CITY OF ALBUQUERQUE

February 02, 2012

**Re: Montessori Of The Rio Grande Charter School
Grading and Drainage Plan
Engineer's Stamp Date 1/09/2012 (H12/D008A)**

GDDA PROJECT NO:
10-002
DATE: 2/27/12
DRAWN BY:
CHECKED BY: SMM
SET NO:
SHEET TITLE:
GRADING AND DRAINAGE PLAN

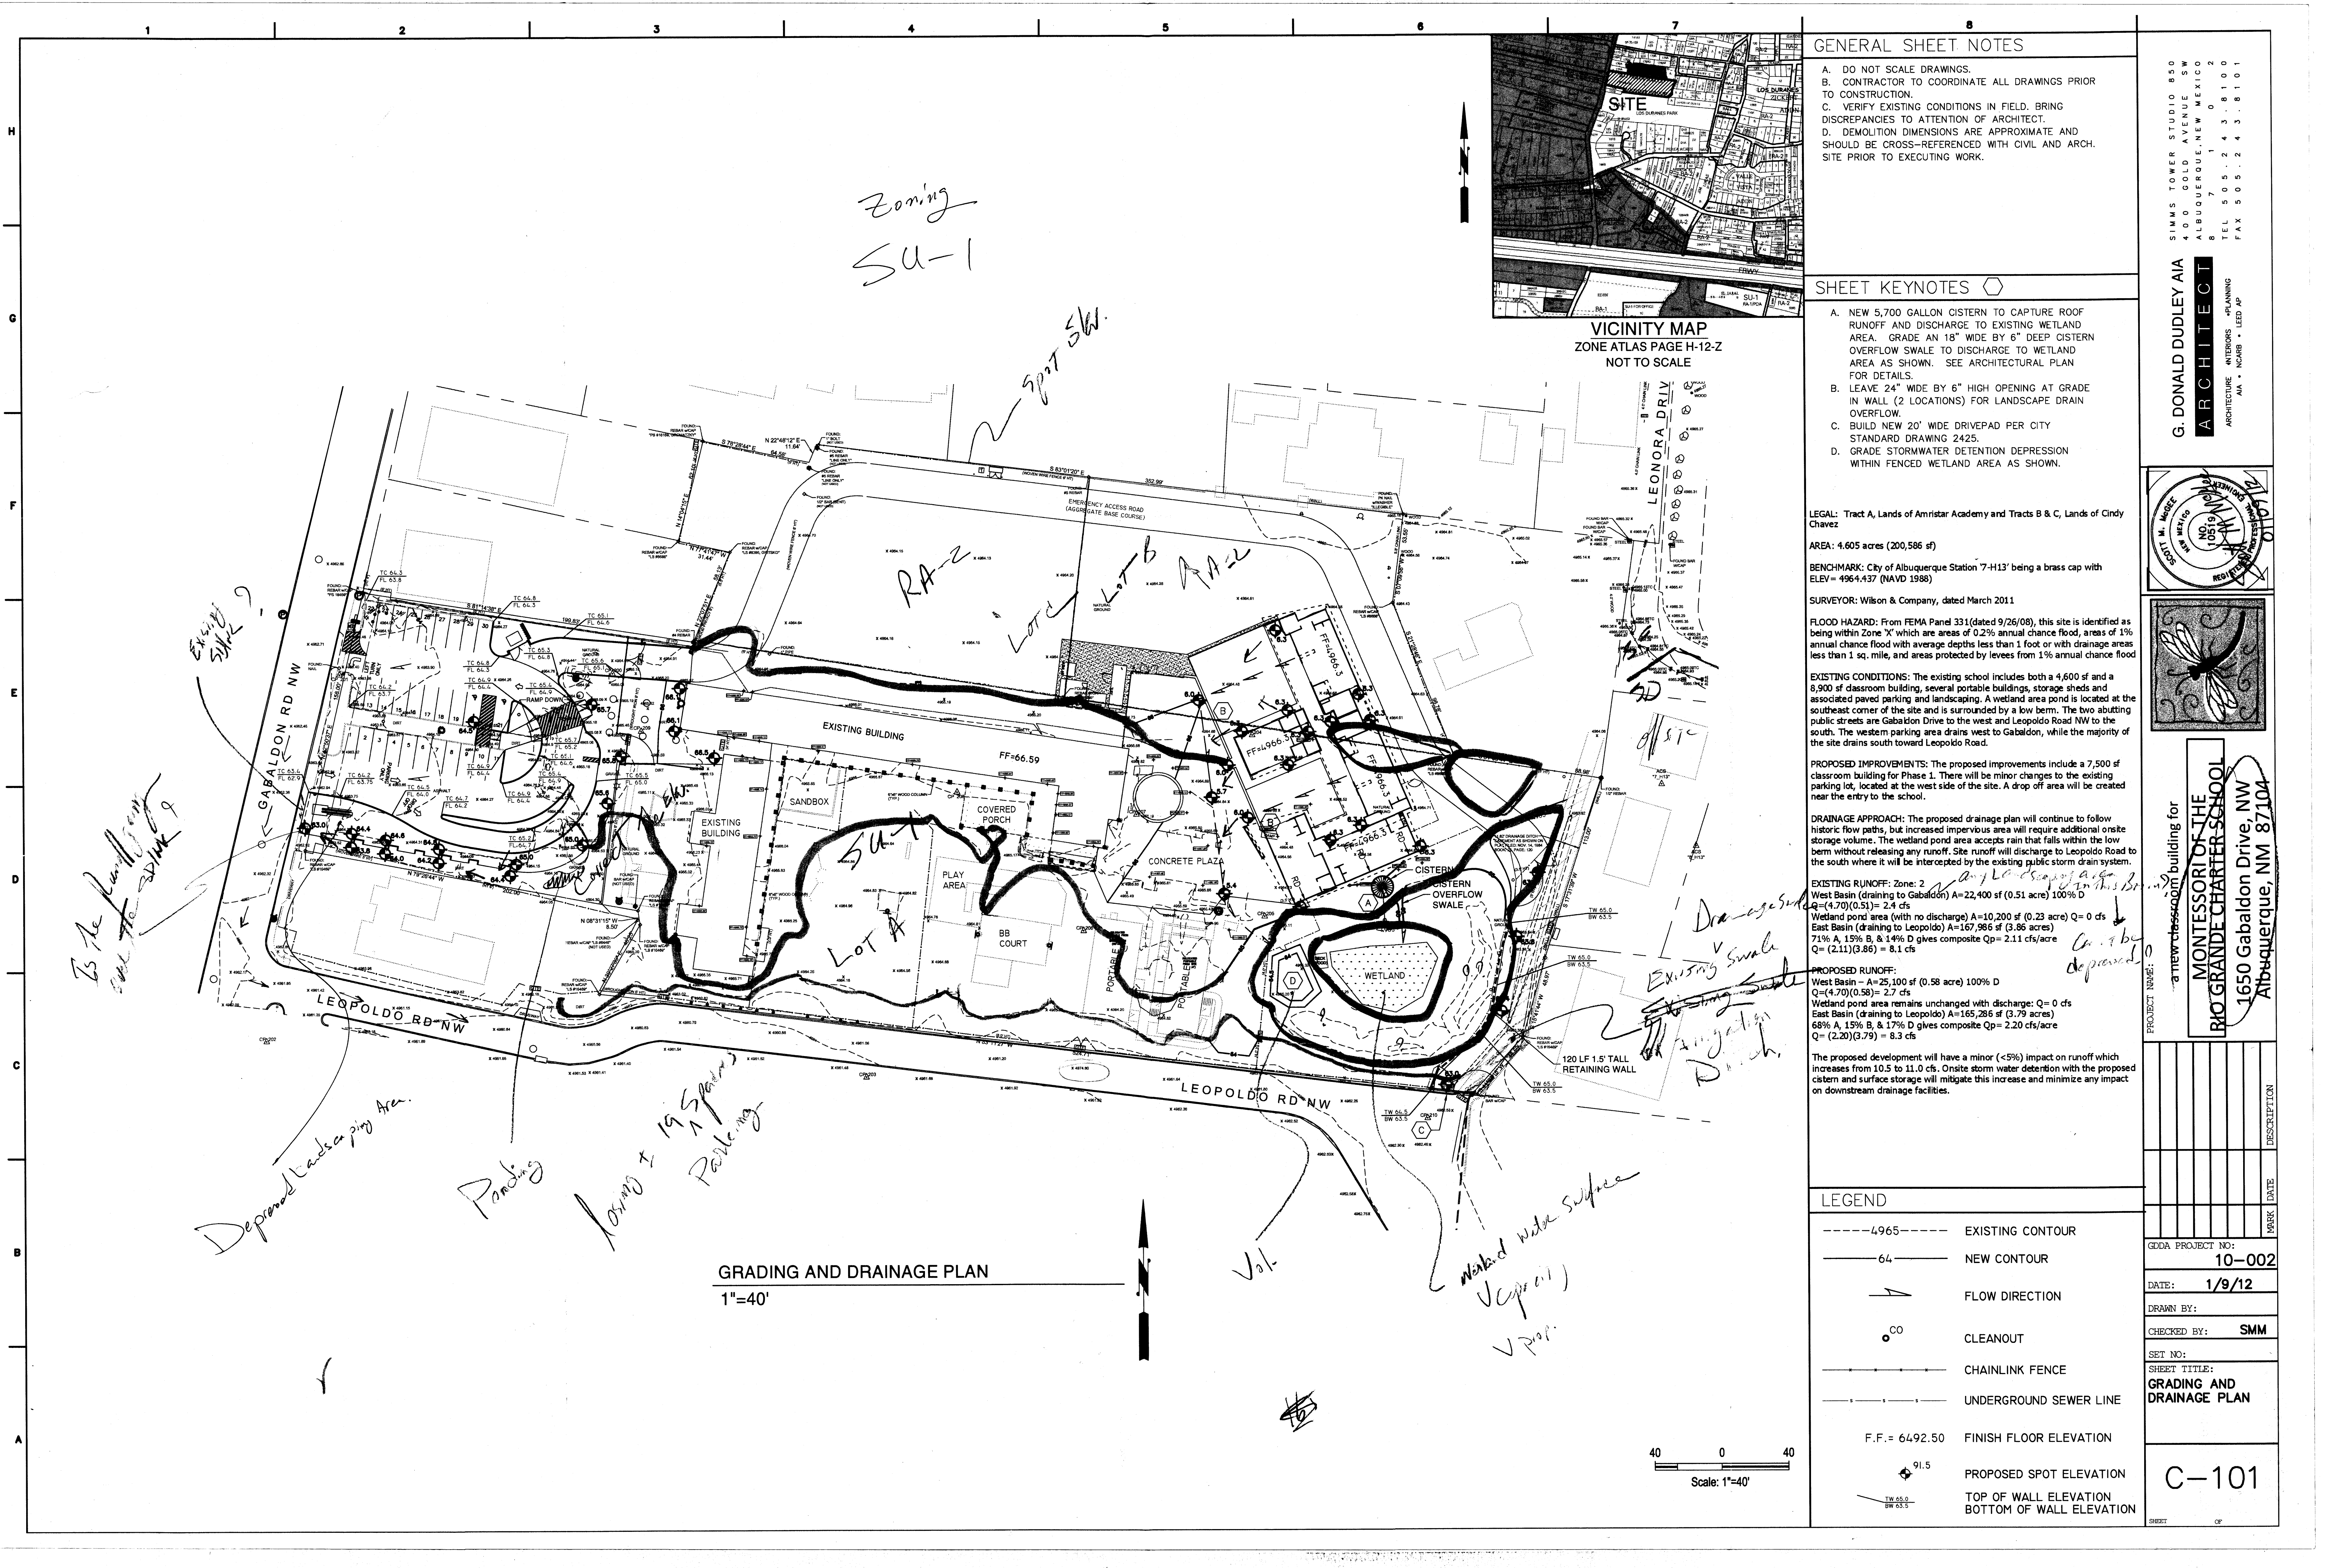
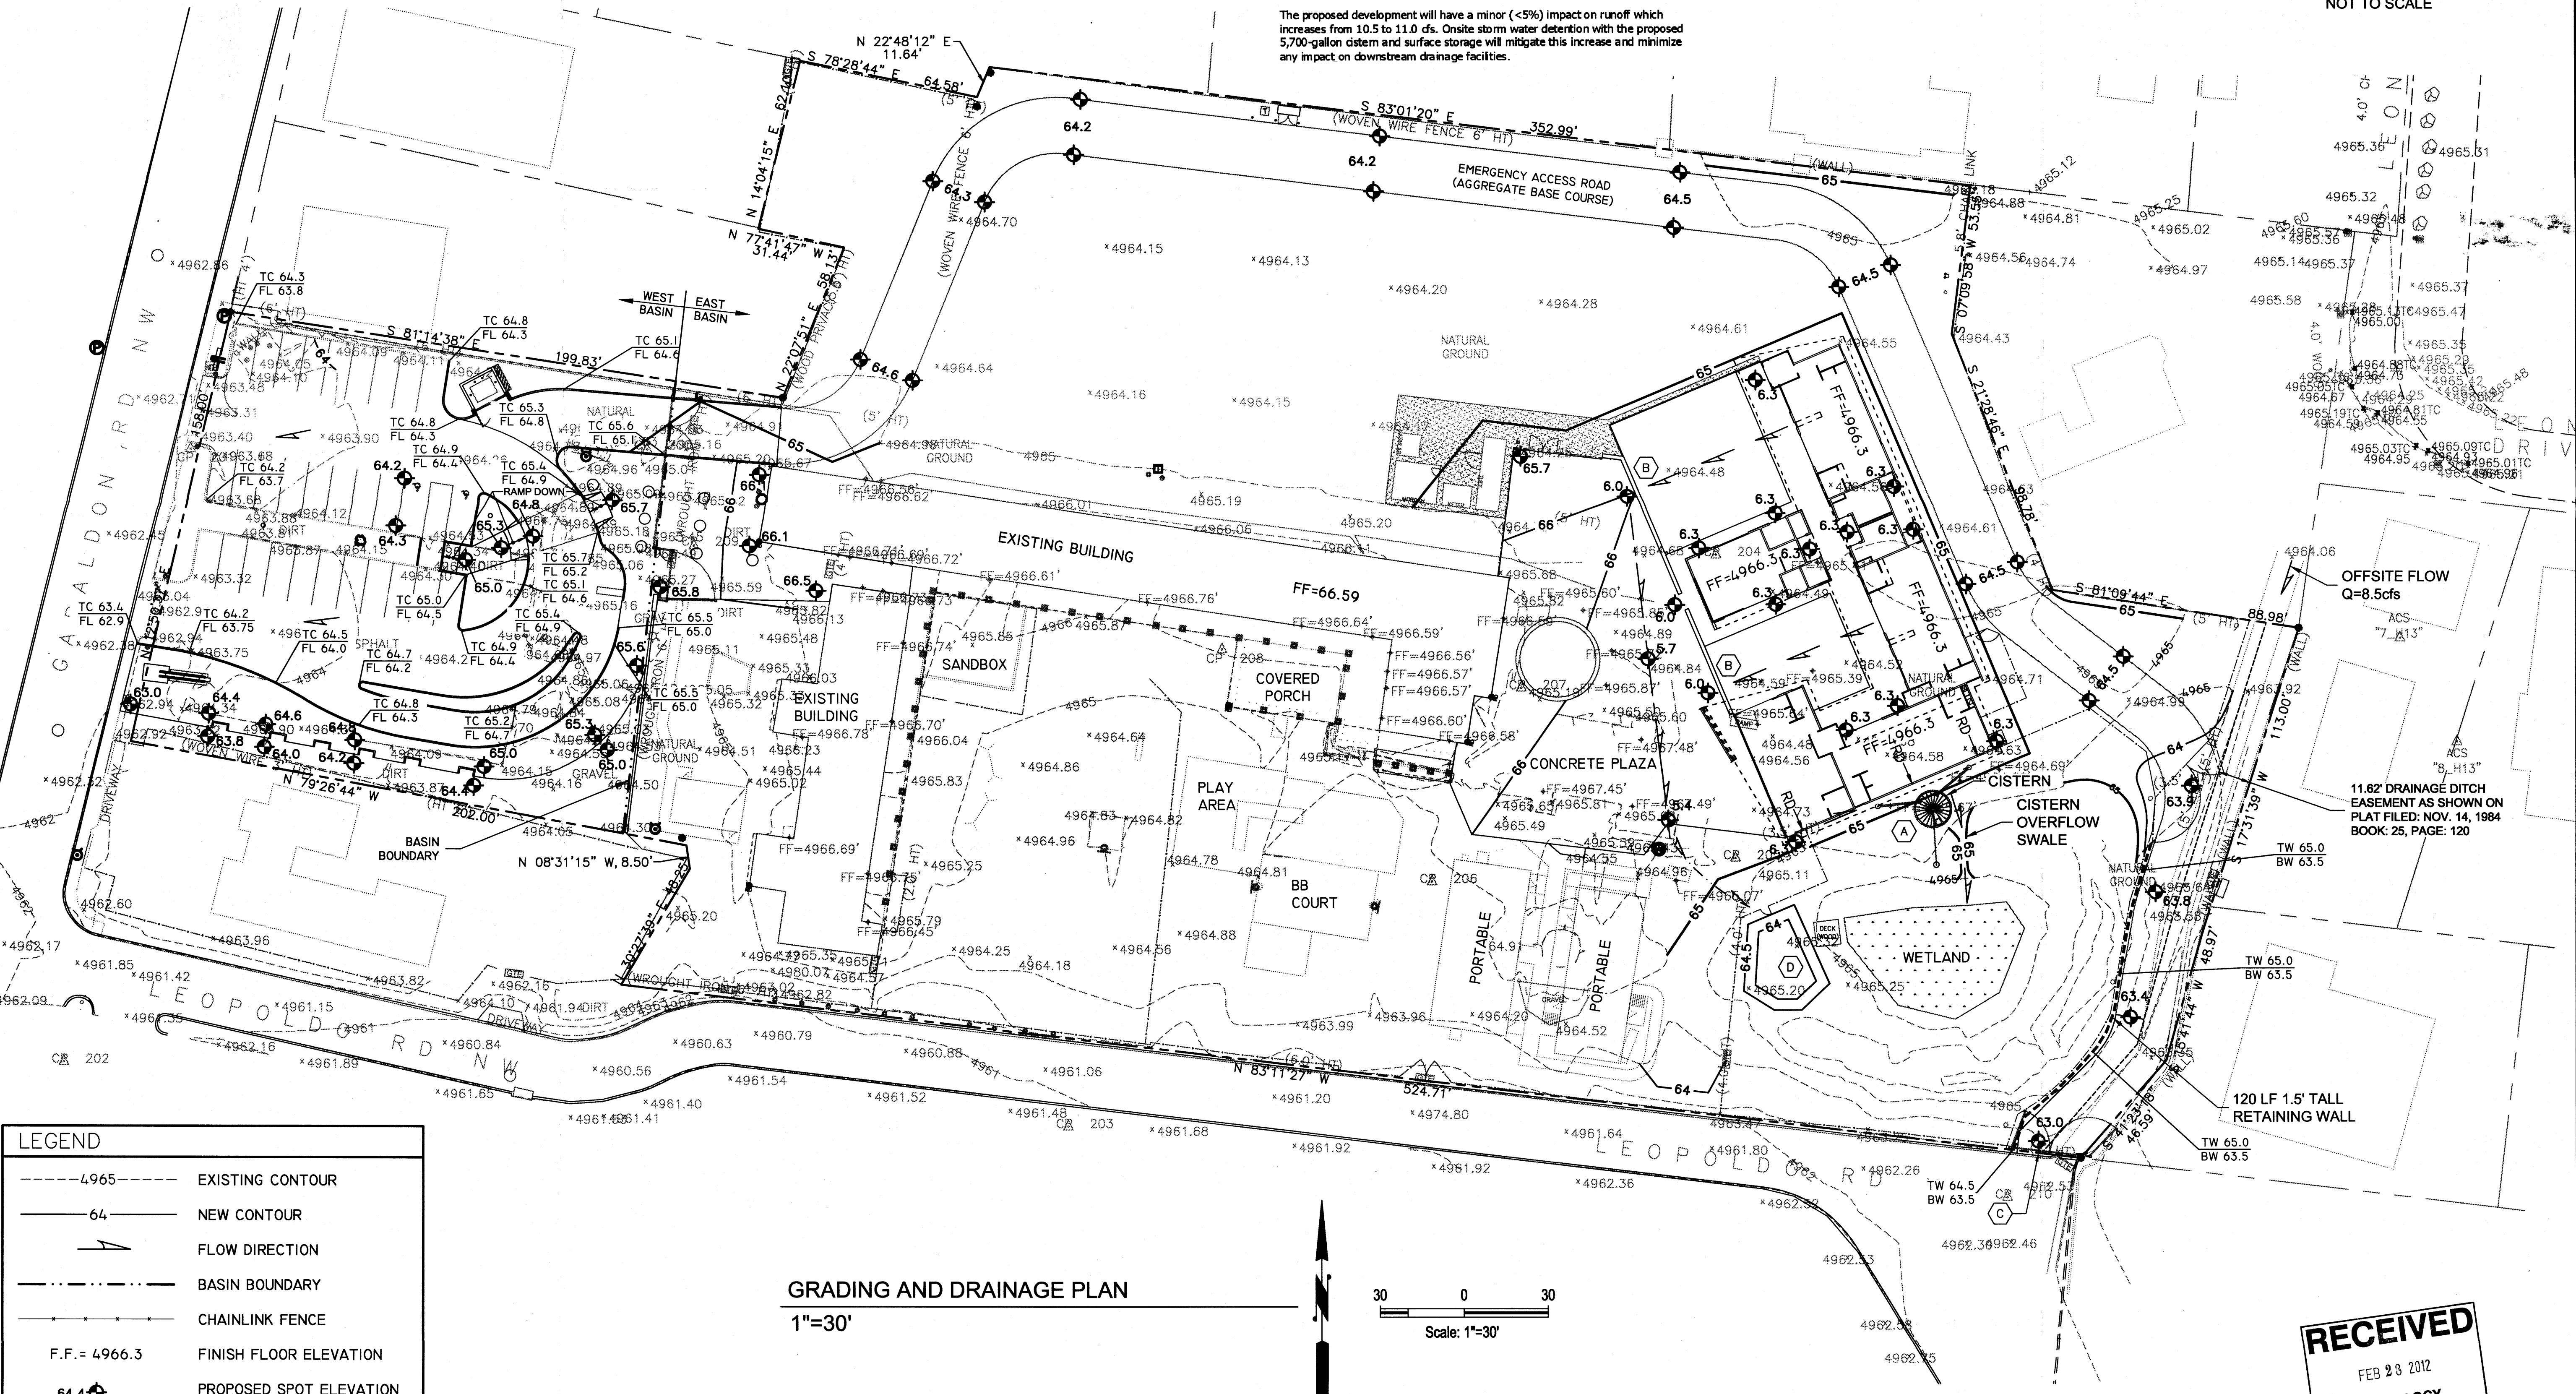
- Limits of the project are not fully reflected on the Vicinity Map.
- Lots B and C are zoned RA-1 and Lot A is zoned SU-1. Is the site being re-platted and rezoned? If so, please provide a copy of the preliminary plat.

- Provide more spot elevations along the boundary of Lots B and C. Increase the text size.
- How is the emergency access road being graded? Will it be super elevated? Provide spot elevations for this road.

- Clearly show the limits of the irrigation ditch on the plans. MRGCD approval will be required for any changes to the existing irrigation ditch.
- Are there any offsite runoff entering this site?

- It is mentioned on the plan that the changes to the parking lot are minor. Losing +/- 18 parking spaces does not appear to be minor changes.
- West basin runoff was increased slightly. Please depress the landscaping areas to retain portion of the runoff to match the exiting runoff.

- The area just south of the entrance appears to drain over the sidewalk. Please depress the landscaping to retain portion of the runoff. Please make sure that runoff does not drain to the property located south of the driveway.

- There are two spot elevations that are at 65.00 on the south side of the driveway. Please correct the elevations.
- Show the basin layout on the plan.

- Provide pond calculations for the existing pond and proposed ponds.
